TfNSW Reference: SYD26/01995/04
DPHI's Reference: SSD-78268465

**EXHIBITION OF ENVIRONMENTAL IMPACT STATEMENT
NEWINGTON COLLEGE REDEVELOPMENT
200-244 AND 221-235 STANMORE ROAD, STANMORE**

TAB A – TfNSW Advisory Comments and Recommended Conditions

SHEET TITLE
STAGE 01 -
TEMPORARY CAR
PARK PLAN

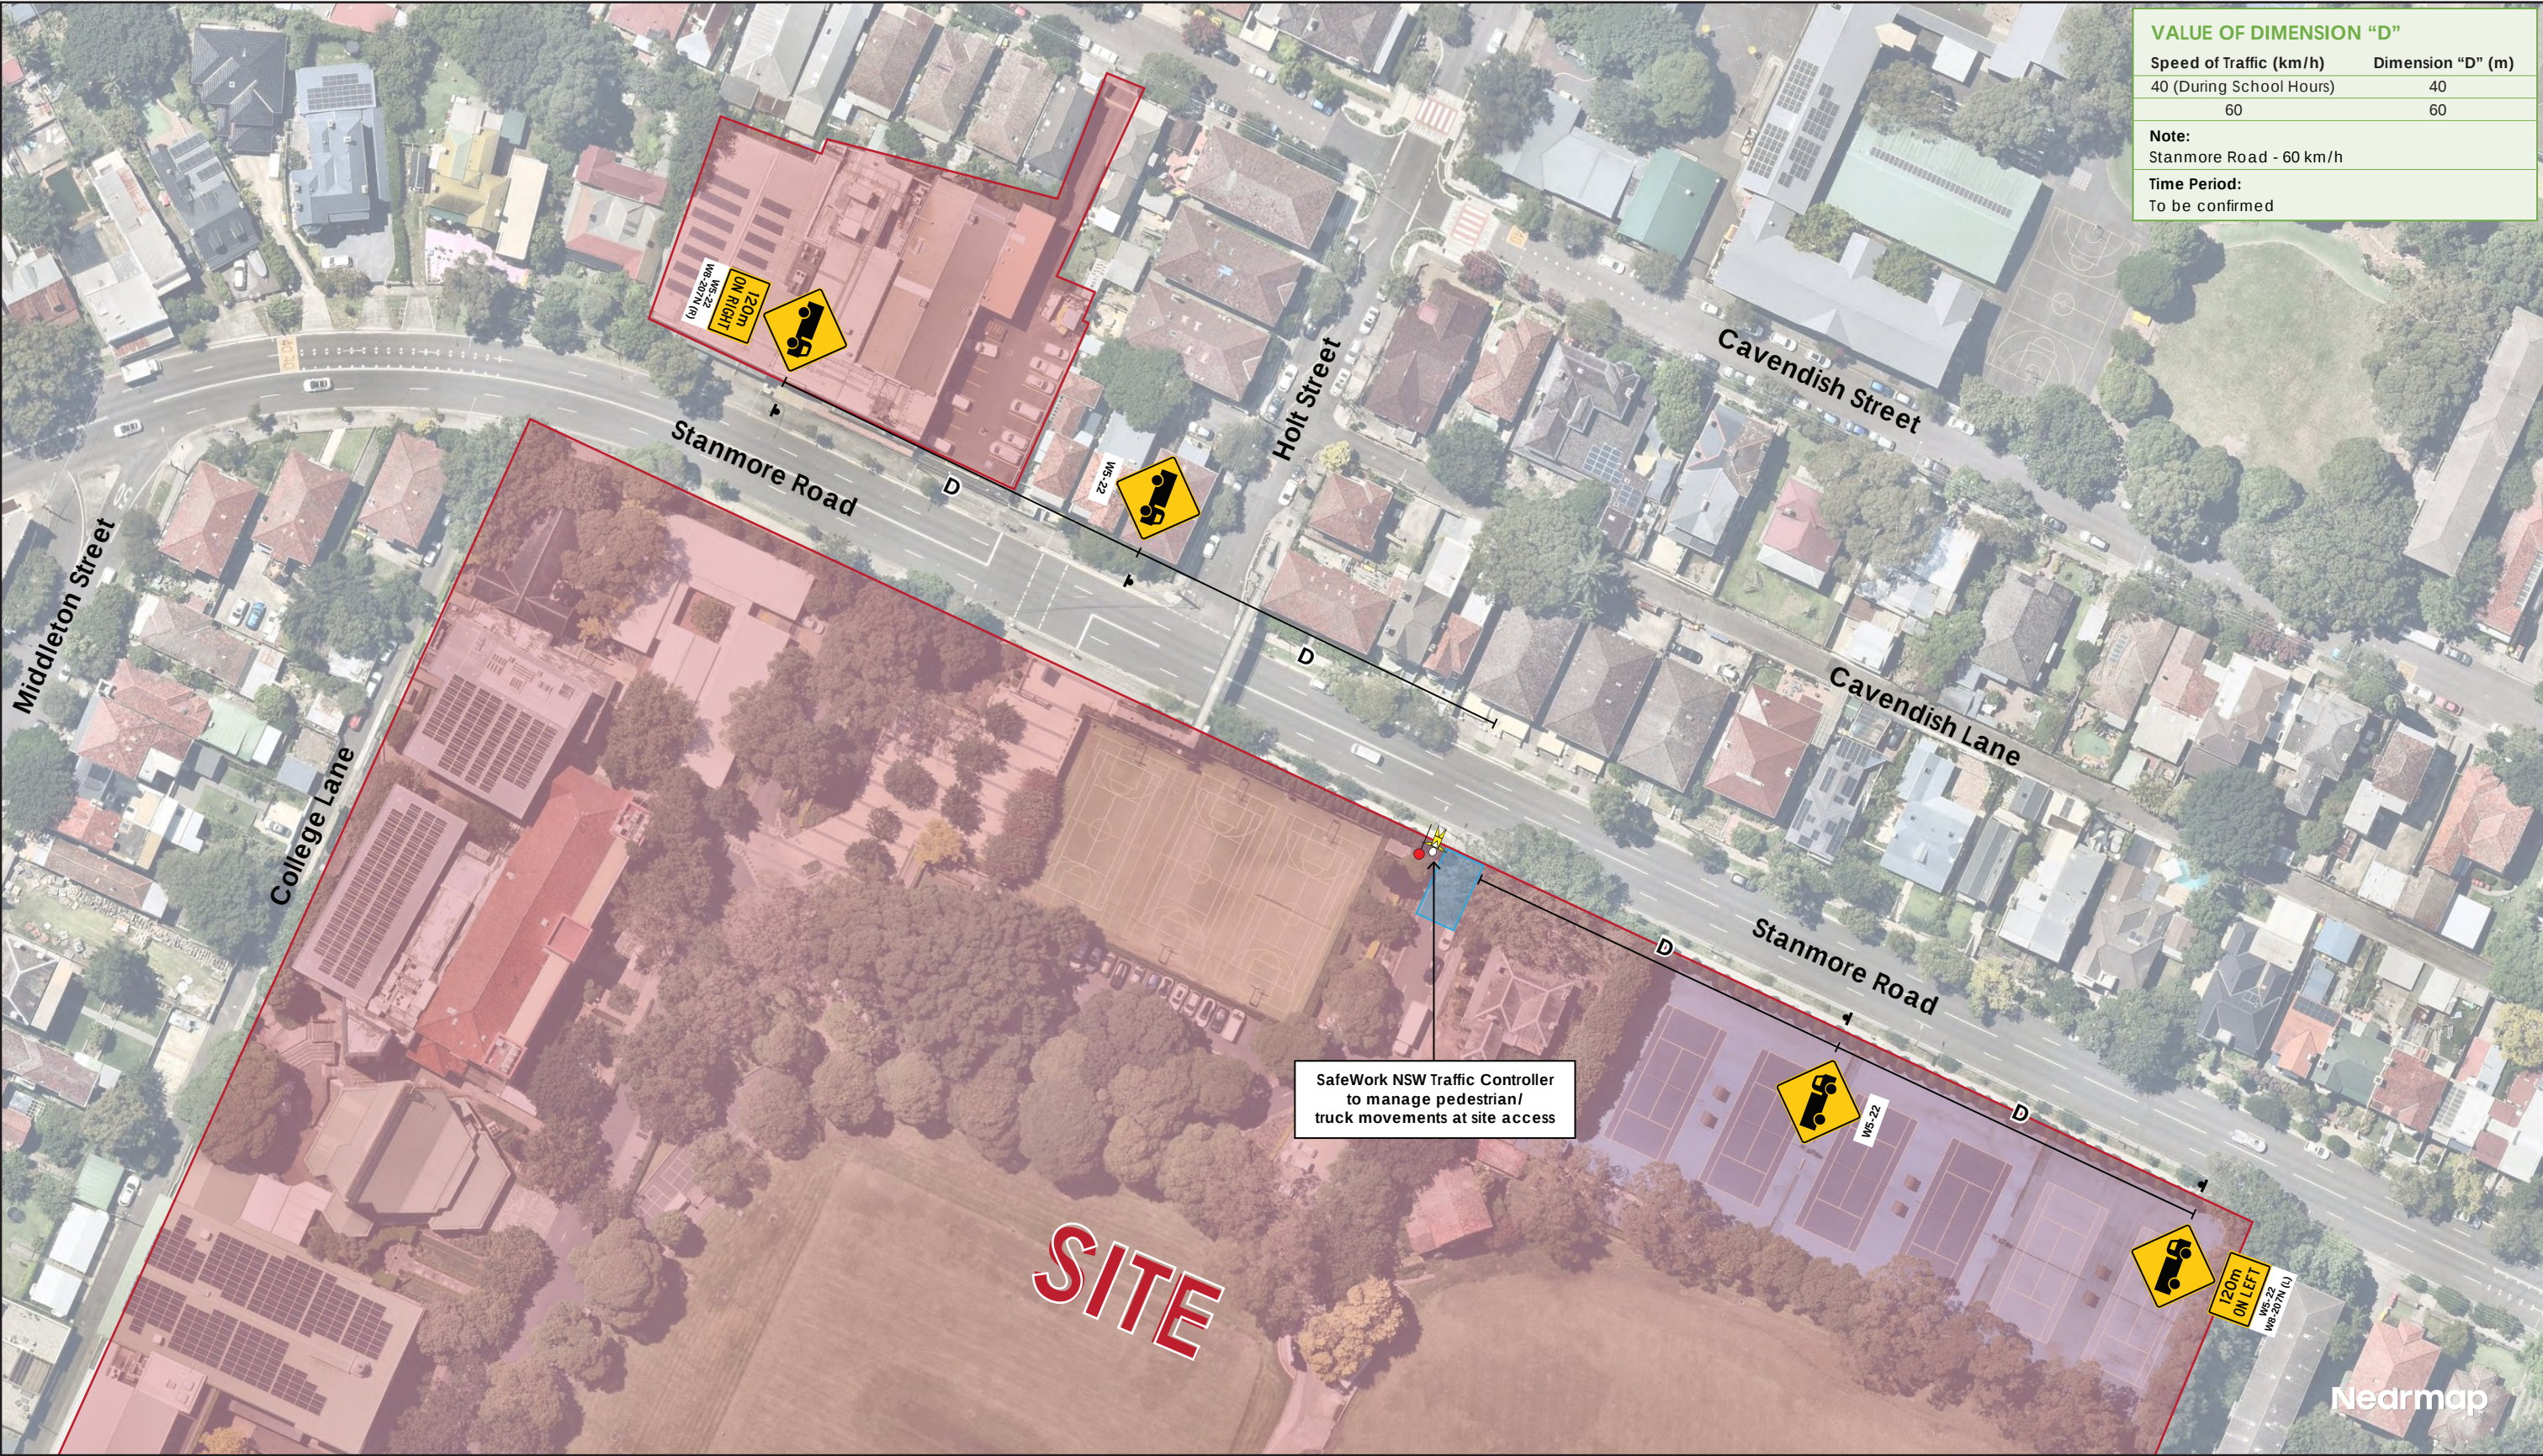
- Any works proposed or required on Stanmore Road (state road) will require the concurrence of TfNSW under section 138 of the *Roads Act 1993*.
- It is noted that a temporary vehicle crossing is proposed on Stanmore Road to provide access to the temporary staff car park during the Stage 1 construction activities, located on the existing tennis courts on the north-eastern corner of the site, depicted in Appendix B of the Preliminary Construction Traffic and Pedestrian Management Plan prepared by Traffix dated 22 April 2026.
- It is noted that for the Concordia Building site access, the entry driveway is proposed on Cavendish Street and exit only proposed onto Stanmore Road, with left turn movements only permitted.

1. The proposed temporary vehicular access on Stanmore Road and associated car parking areas shall be designed in accordance with AS 2890.1- 2004 (Parking Facilities, Part 1: Off-Street car parking) and shall be designed to accommodate the simultaneous entry/exit movements of vehicles to/from Stanmore Road. Vehicle swept path plans shall be provided to demonstrate a B99 vehicle entering the site while a B85 vehicle is leaving the site, with the necessary manoeuvring clearances in accordance with AS 2890.1: 2004.

2. The temporary vehicular access on Stanmore Road shall be for the temporary staff car park use only during the Stage 1 works. The temporary access shall be closed and reinstated to kerb and gutter following the completion of the Stage 1 works.

3. The design and construction of the temporary vehicle access, kerb and gutter reinstatement and associated works on Stanmore Road shall be in accordance with TfNSW requirements.

6. All vehicles are to enter and exit the site in a forward direction.
7. Sight distances from the proposed vehicular crossing to road users on Stanmore Road are to be in accordance with AS 2890. Vegetation and proposed landscaping/fencing must not hinder sight lines to and from the vehicular crossing to motorists, pedestrians, and cyclists.

8. An 'All Traffic Left' sign is to be installed at the Concordia Building site vehicular exit, as well as the temporary staff car park exit, facing motorists exiting the site to Stanmore Road.
